Application: SSI 7485

I write regarding the proposed modification to M4-M5 Link, Mod 2 The Crescent overpass and changes to pedestrian infrastructure in North Annandale, Rozelle and Rozelle Bay Foreshore area.

Figure 4-2 Pedestrian and cyclist bridge infrastructure options

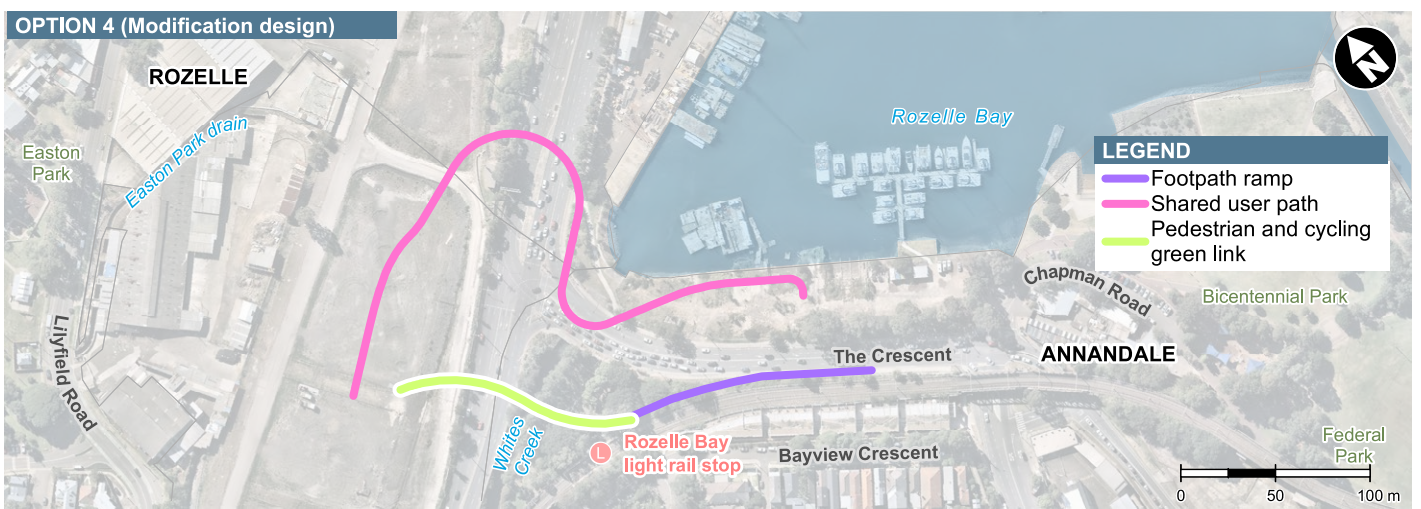
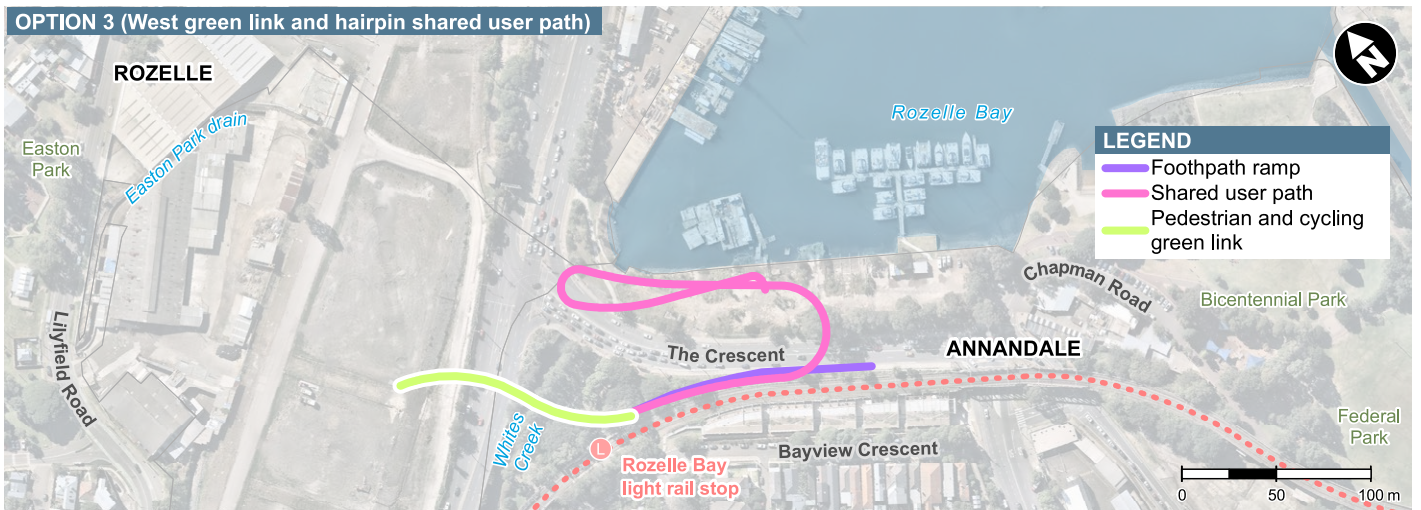
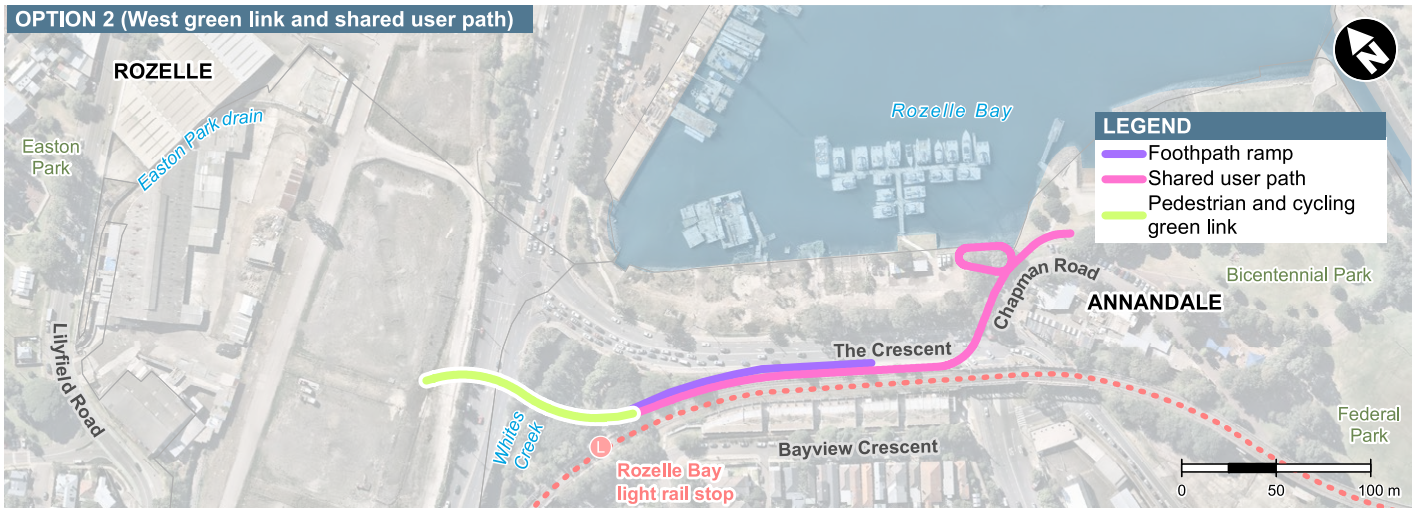
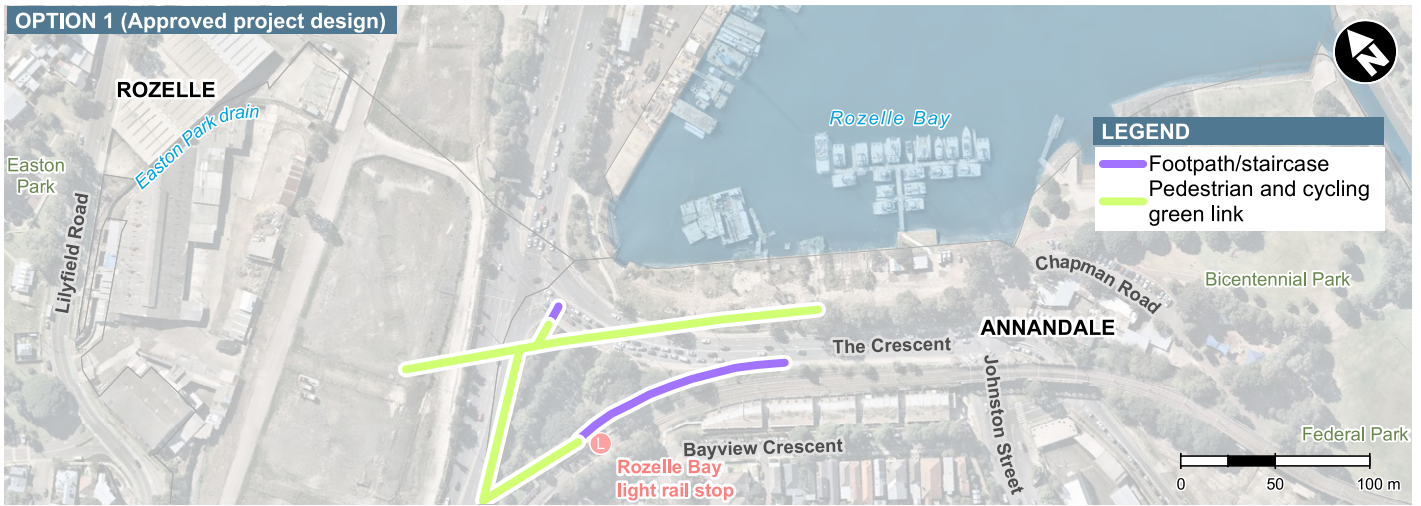
I request RMS work with the community to explore alternate design options to the proposed new car overpass design and the changed pedestrian and cyclist links. I am seeking the reinstatement of the safe, direct access from the approved EIS GreenLink to create a continuous green open space connection from the Rozelle Rail yards and Annandale to the foreshore. The GreenLink was more than just a walk way - it put people central to the design, maximising safety, and providing much needed accessible open space for the community now and into the future Bays Precinct design.

Figure 4-4 Elevation: Indicative view of The Crescent overpass

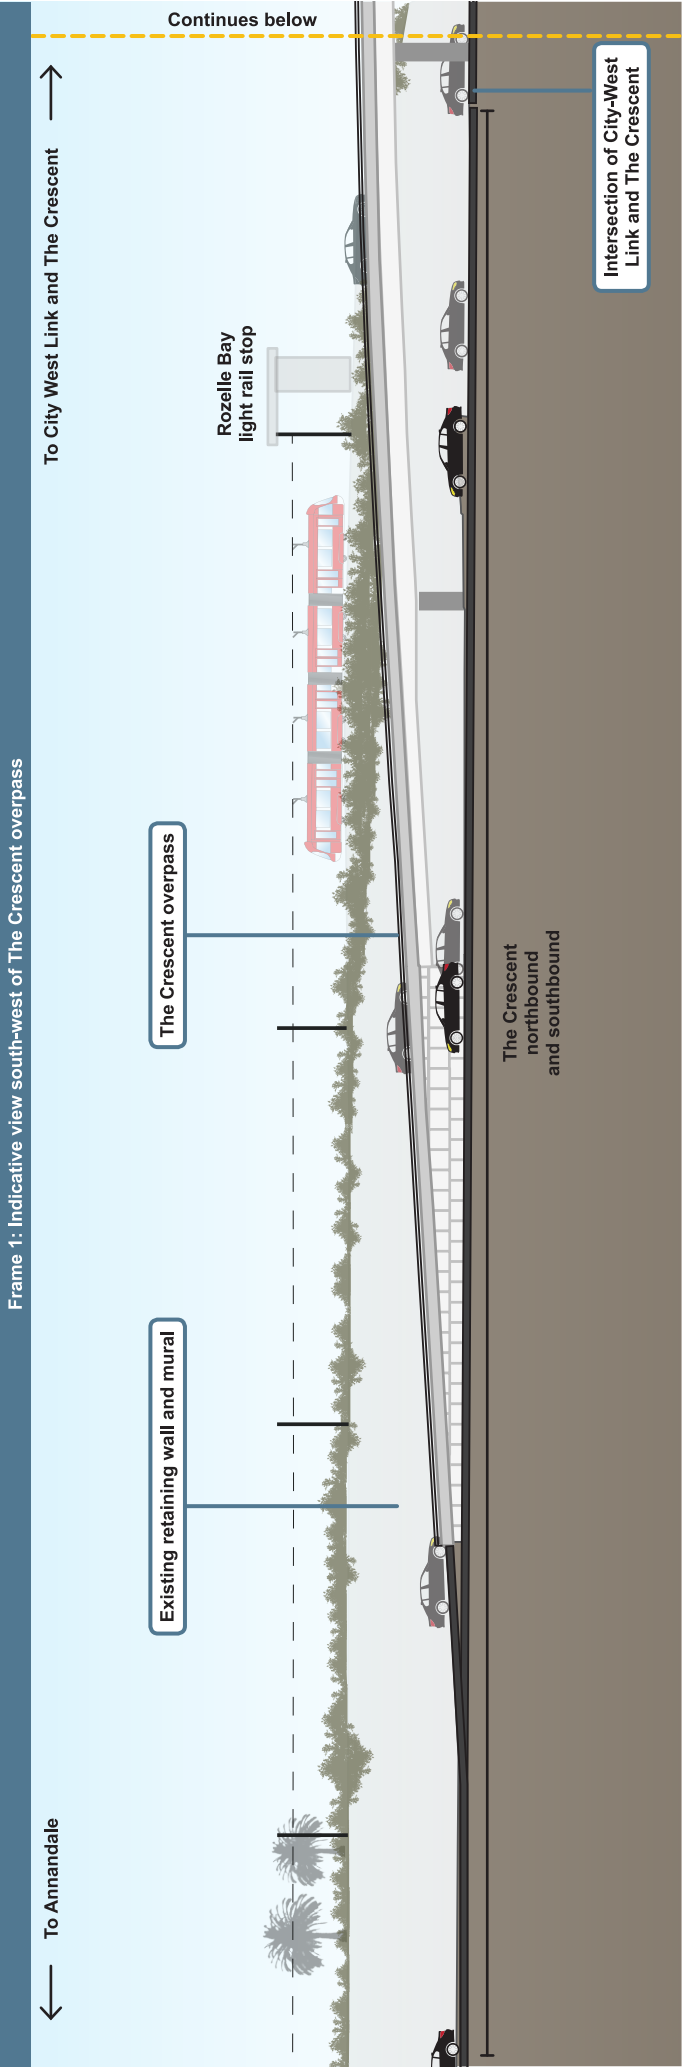
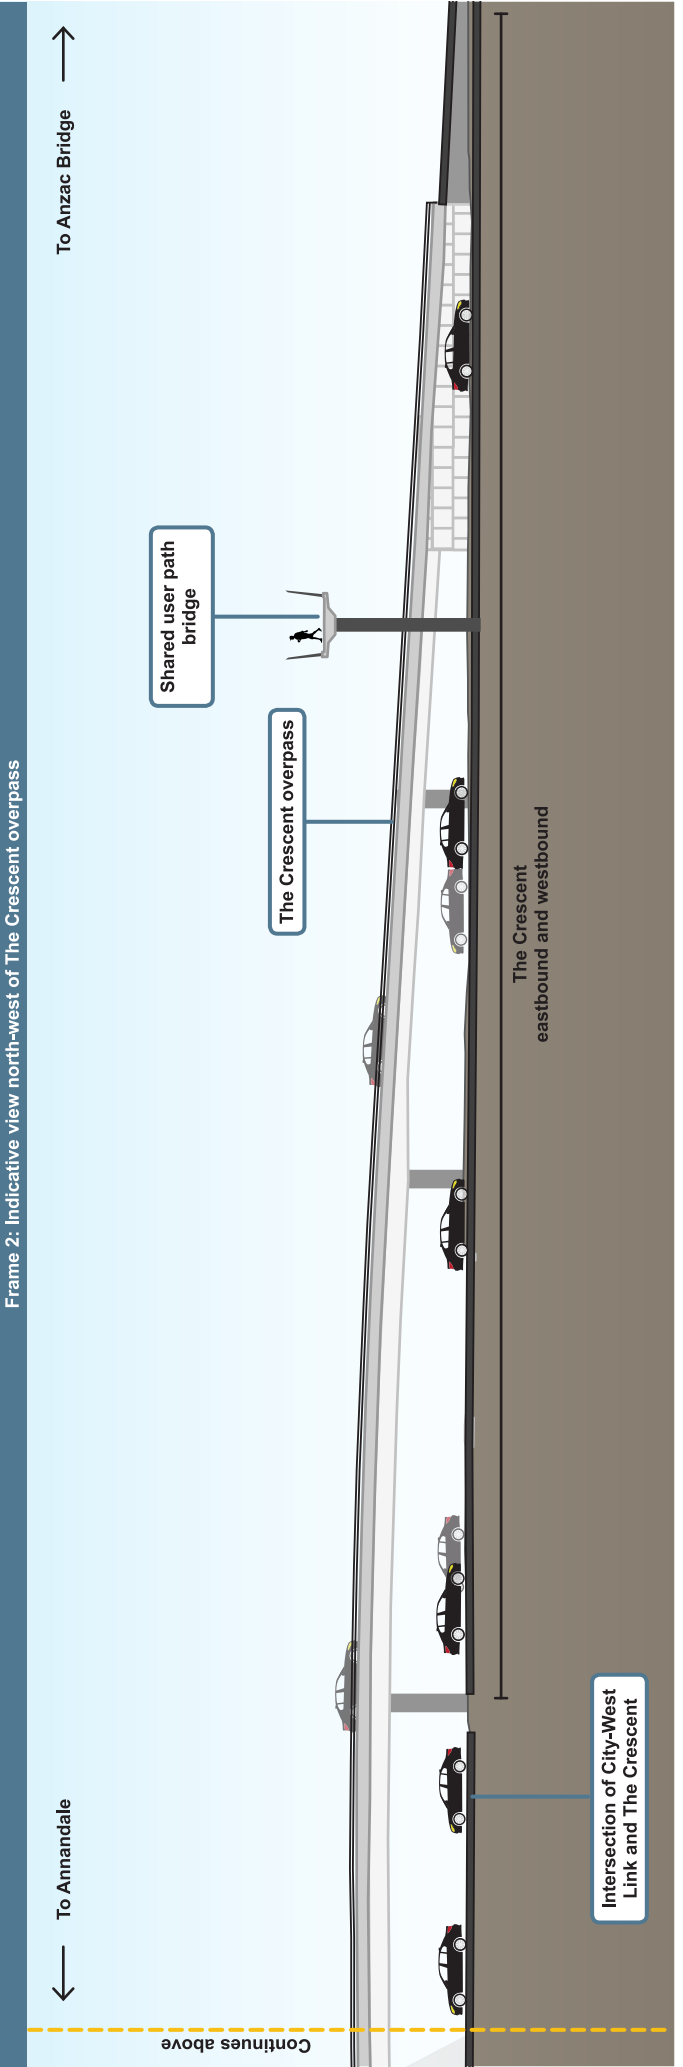
- The significantly reduced safety and increased risk for pedestrians and cyclists with removed access over The Crescent to Bicentennial Park and the increased traffic along Johnson Street.
- Being required to cross five sets of pedestrian lights at The Crescent as my option to reach the foreshore from Annandale or from Rozelle Bay light rail stop.
- Removal of direct active links to the foreshore, cutting the community off from the area and the proposed revitalisation of the entire Bays Precinct, including linking the Light Rail and Bus stops to a Ferry wharf and Metro station.
- Urban and landscape design that is being built before a finalised Masterplan for the area.
- Traffic changes that limit movements around the suburb and create further congestion in the local streets of Annandale, Forest Lodge, Glebe, Lilyfield and Rozelle with no planning to deal with these.

- THAT NO MORE TREES THAN IS ESSENTIAL BE REMOVED
- THAT A MASSIVE TREE PLANTING BE IMPLEMENTED TO SOMEWHAT COMPENSATE FOR THE HUGE NUMBER OF TREES THAT HAVE ALREADY BEEN REMOVED
- THAT THE TOTALLY RIDICULOUS & UNACCEPTABLE OVERPASS FROM THE CRESCENT TO VICTORIA ROAD BE ABANDONED & THE DESIGN REVERTS TO THE ORIGINAL PLAN
- THAT THE AIR STACKS FOR THE TUNNEL FROM IRON COVE BRIDGE TO WHITE BAY BE PROPERLY FILTERED & POSITIONED NOT TO DO ANY HARM TO ROZELLE PRIMARY SCHOOL

Figure 4-6 Elevation: Indicative view of Rozelle Rail Yards Pedestrian and Cycling Green Link

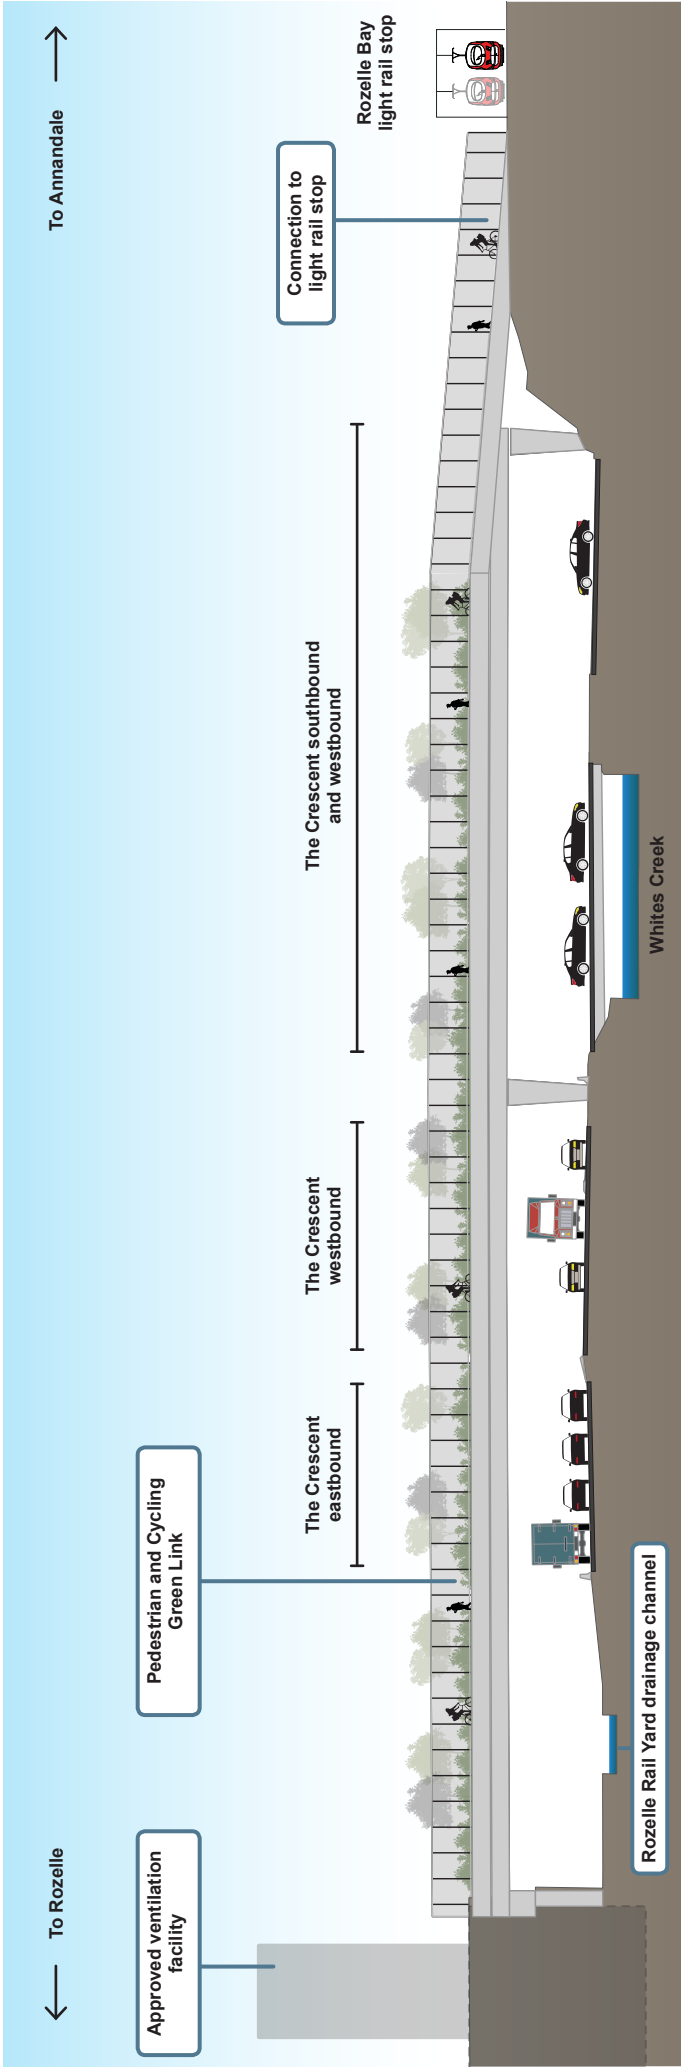
- Reinstate the GreenLink connecting communities and green open space from Rozelle to Bicentennial Park
- Relocate and design pedestrian and cyclist connections that are continuous, safe and direct.
- Design the modification infrastructure and active links in response to the character of the suburbs, the location of the foreshore and it's potential future development.
- Provide pedestrian and cyclist paths that maximise people safety and do not force them onto busier streets, unsafe concrete plazas and caged walkways.
- Integrate active and direct connections to all active transport – including the future Metro West and Foreshore Ferry Wharf
